Application for Exemption from Site Plan Review

PROJECT NAME: Portland Public Safety

PROJECT ADDRESS: 109 Middle Street, Portland Me

PROJECT DESCRIPTION: (Please Attach Sketch/Plan of Proposal/Development)
Exterior concrete pad for emergency generator.

6x16  
GEL  
PAD

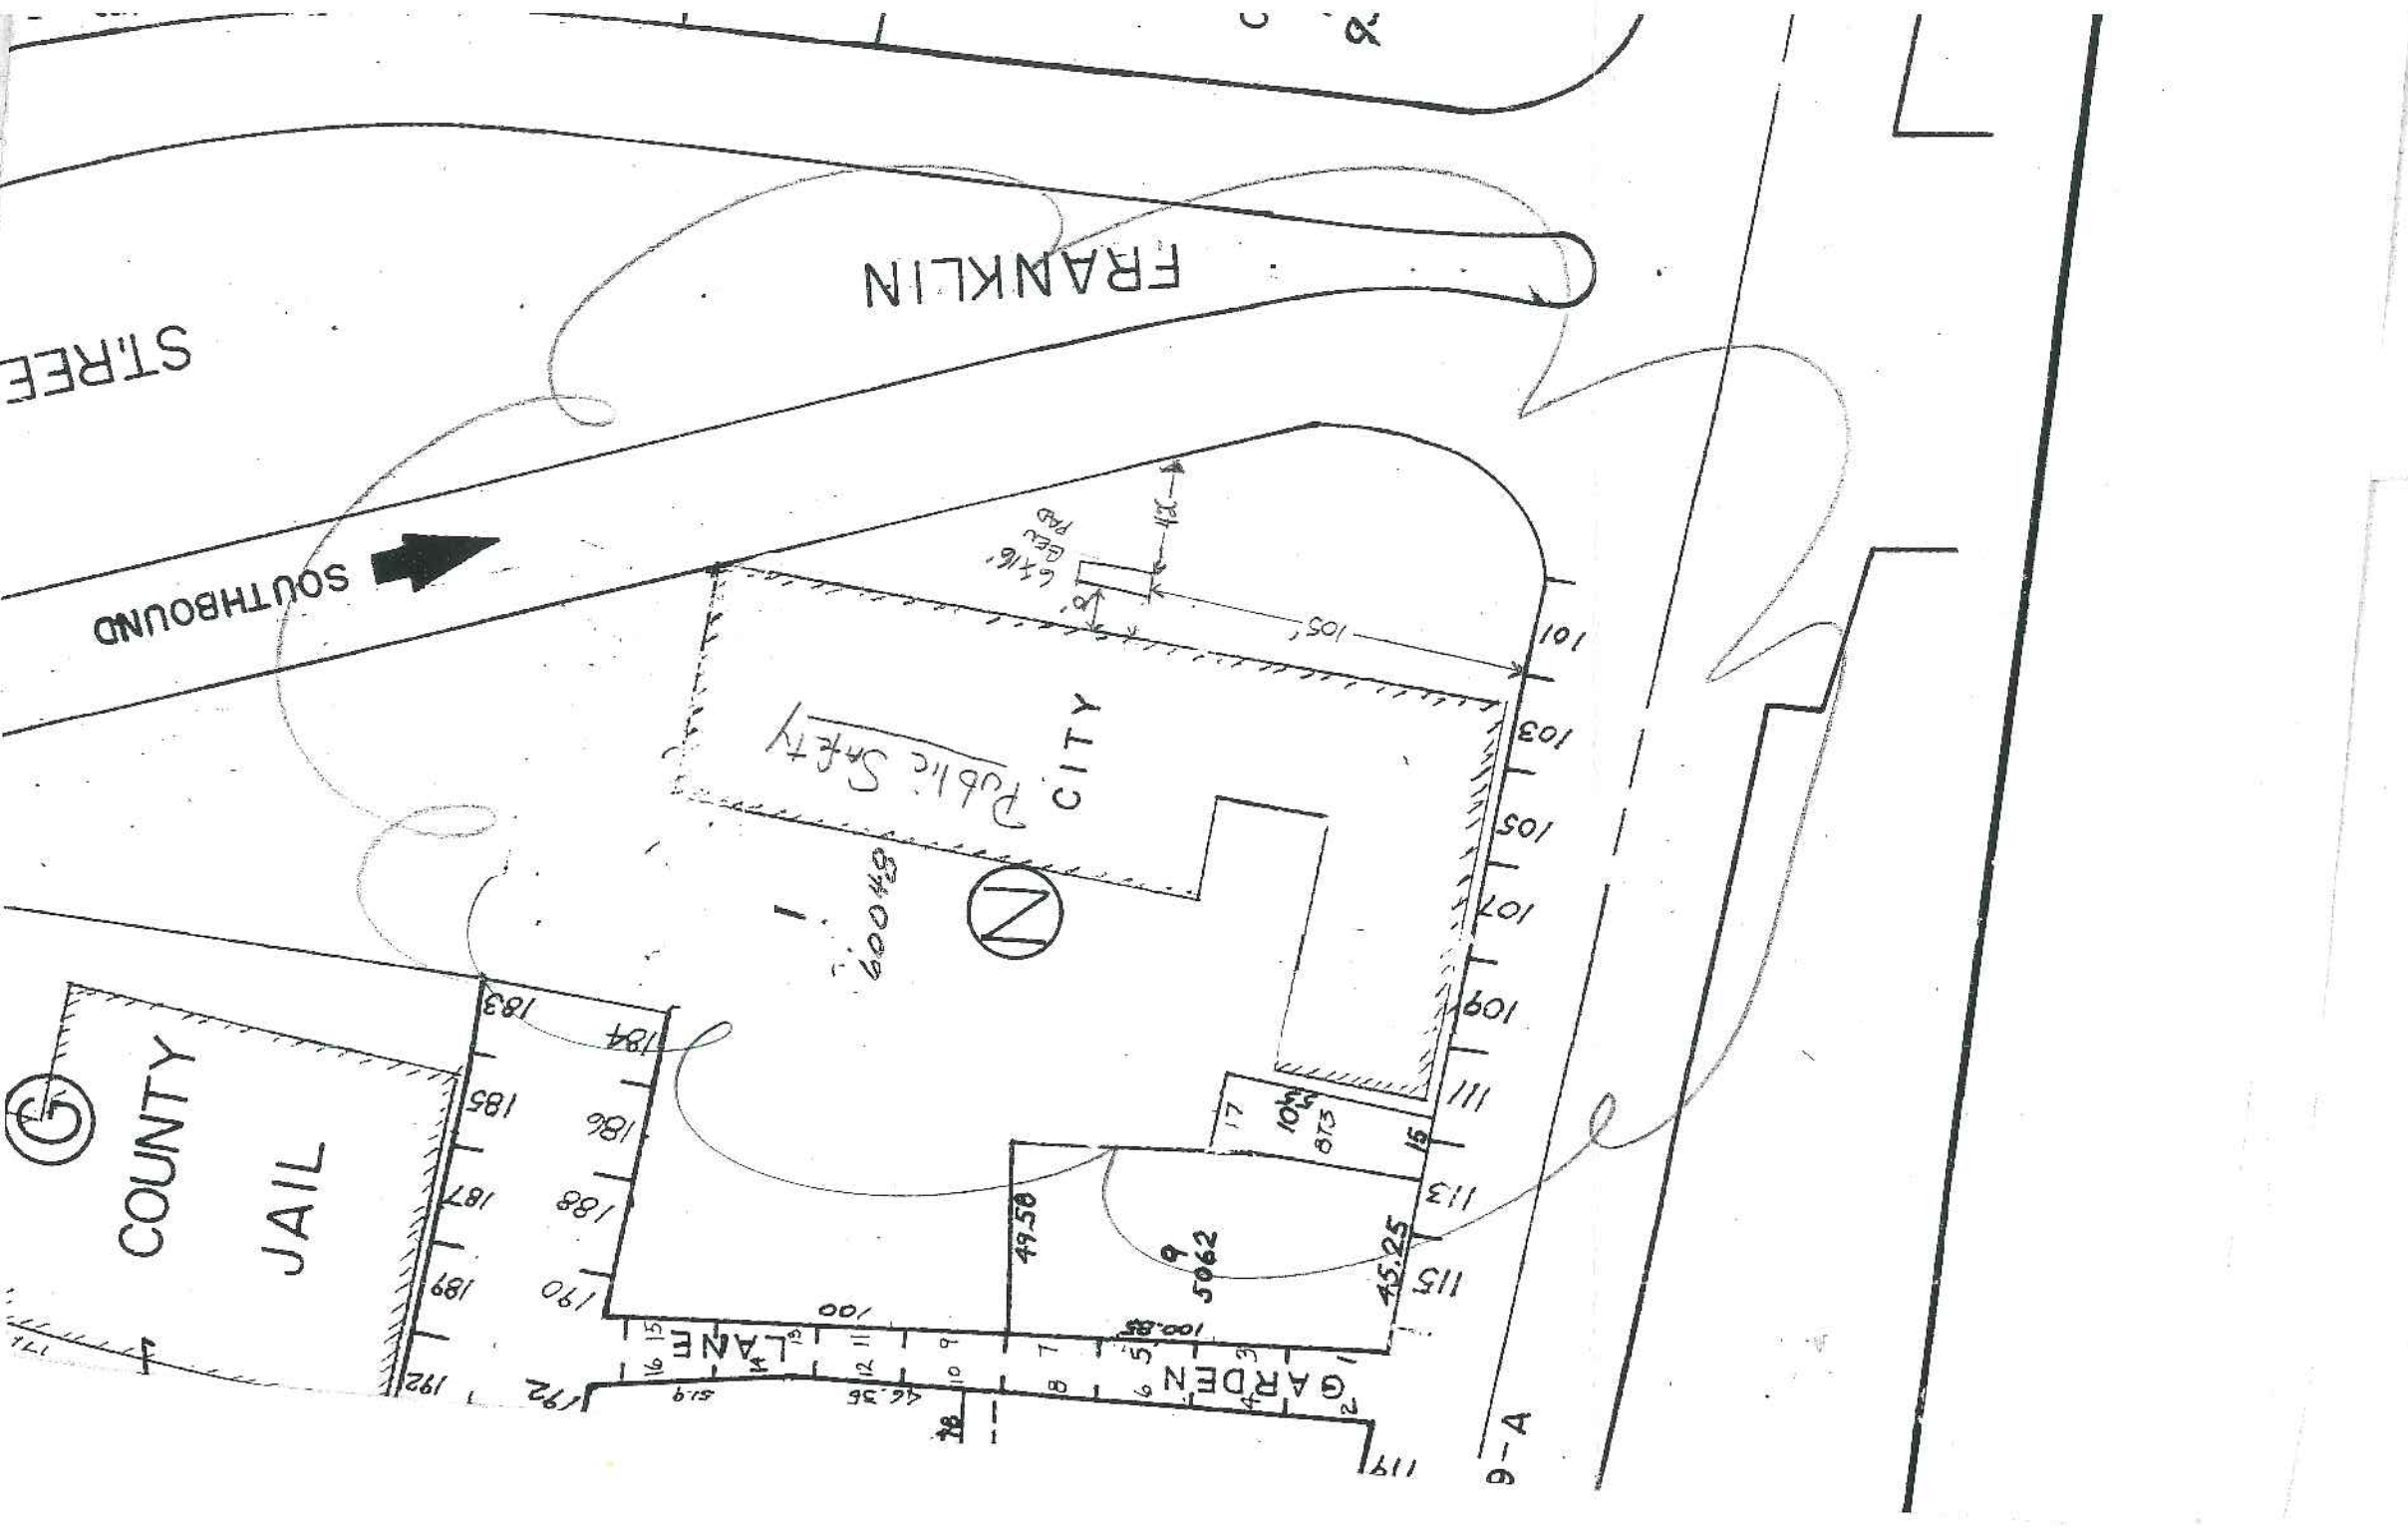
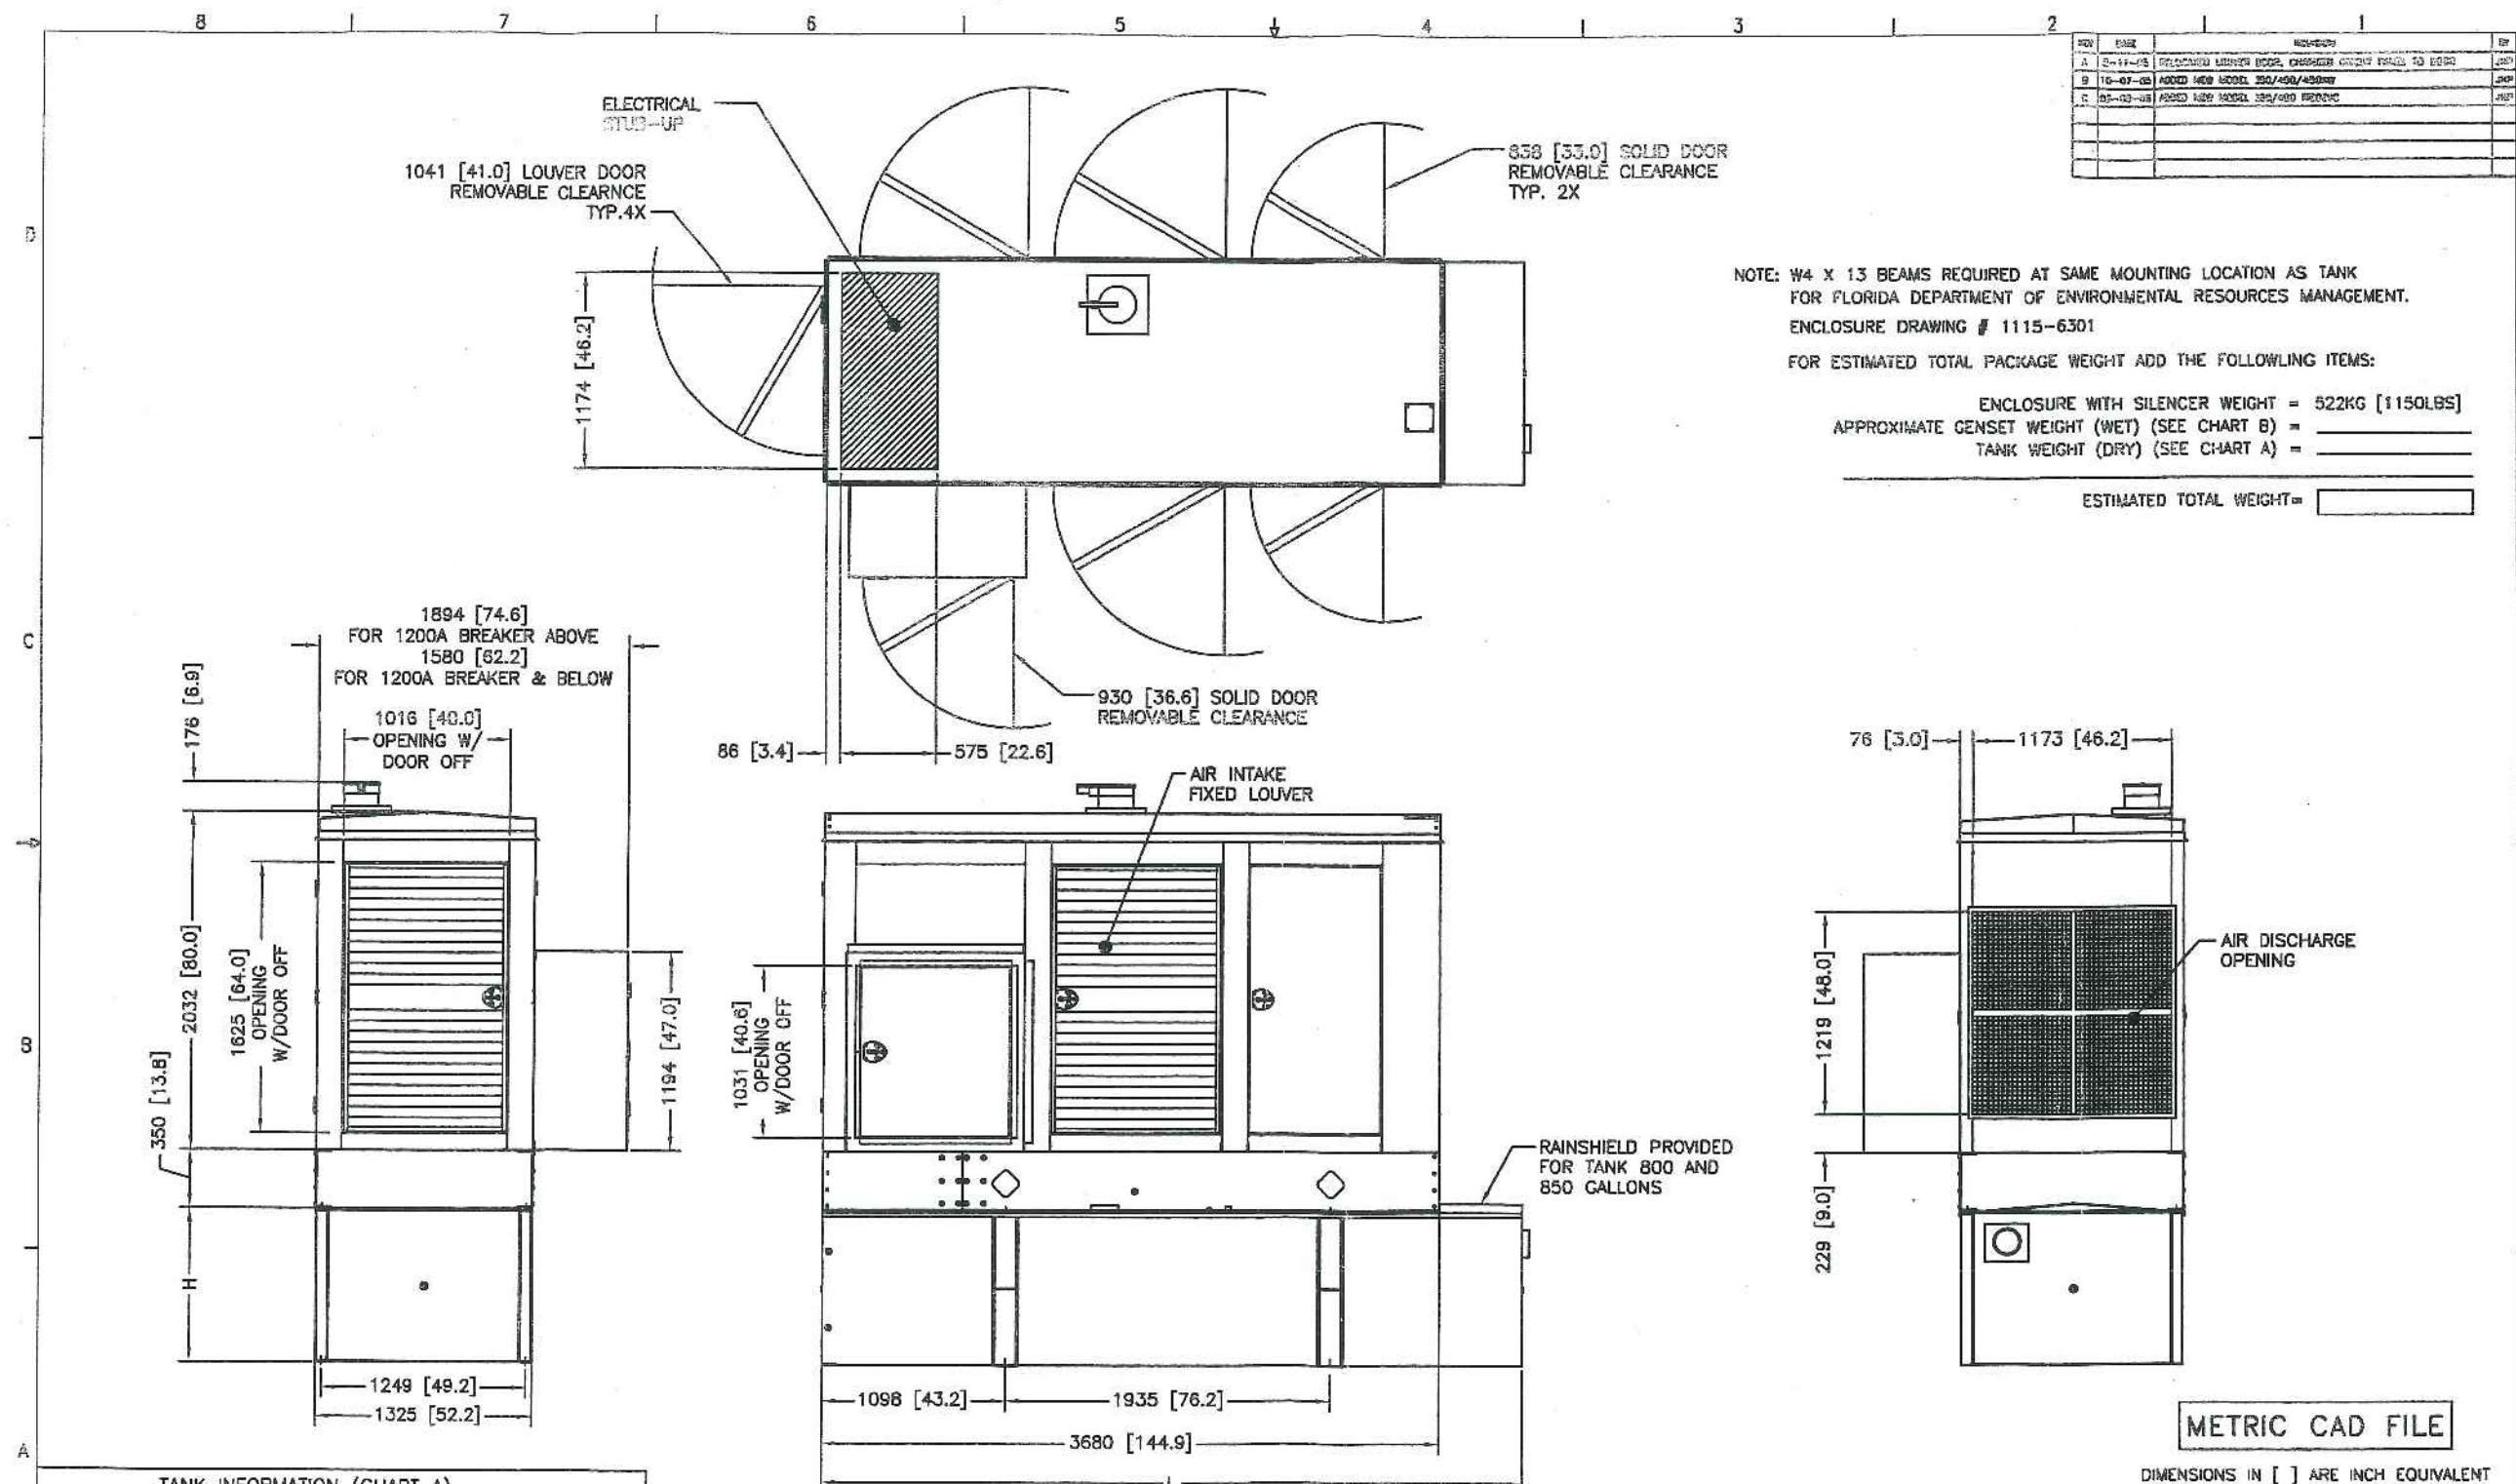
We talked about this at our development review meeting. The noise levels for this are extremely high compared to other facilities. David Margolis-Pineo noted that there are specifications for a muffler on one of the sheets, but it is unclear if a muffler is proposed. The most that can be done to minimize noise and provide screening is important.

I am particularly interested in the estimated reduction in decibels from the generator. Thank you.

- 1) The muffler silencer is being installed and it is being upgraded from Industrial Grade Silencer to Critical Grade Silencer.
- 2) The weekly testing of the current generator happens 1 time per week on Wednesday between 9 a.m. and 9:20 a.m. The new generator will be tested on the same schedule.
- 3) The Level #1 enclosure will reduce the noise to approximately 78 dba at 23 feet from the radiator.

- 1) The Level #1 enclosure shall be installed with the generator to attenuate the noise levels.
- 2) Bushes or trees removed for installation of the generator shall be replaced.
- 3) Routine test of the generator shall be conducted on weekdays (Mon. through Friday) between 9 a.m. and 5 p.m.

Level #1 enclosure approx. 78 dba at 23 feet from the radiator: the cost would be \$ 8,800.00 increase. (-16dba)
Level #2 enclosure approx. 68-72 dba at 23 feet from the radiator: the cost would be \$27,800. Increase. (-20dba)
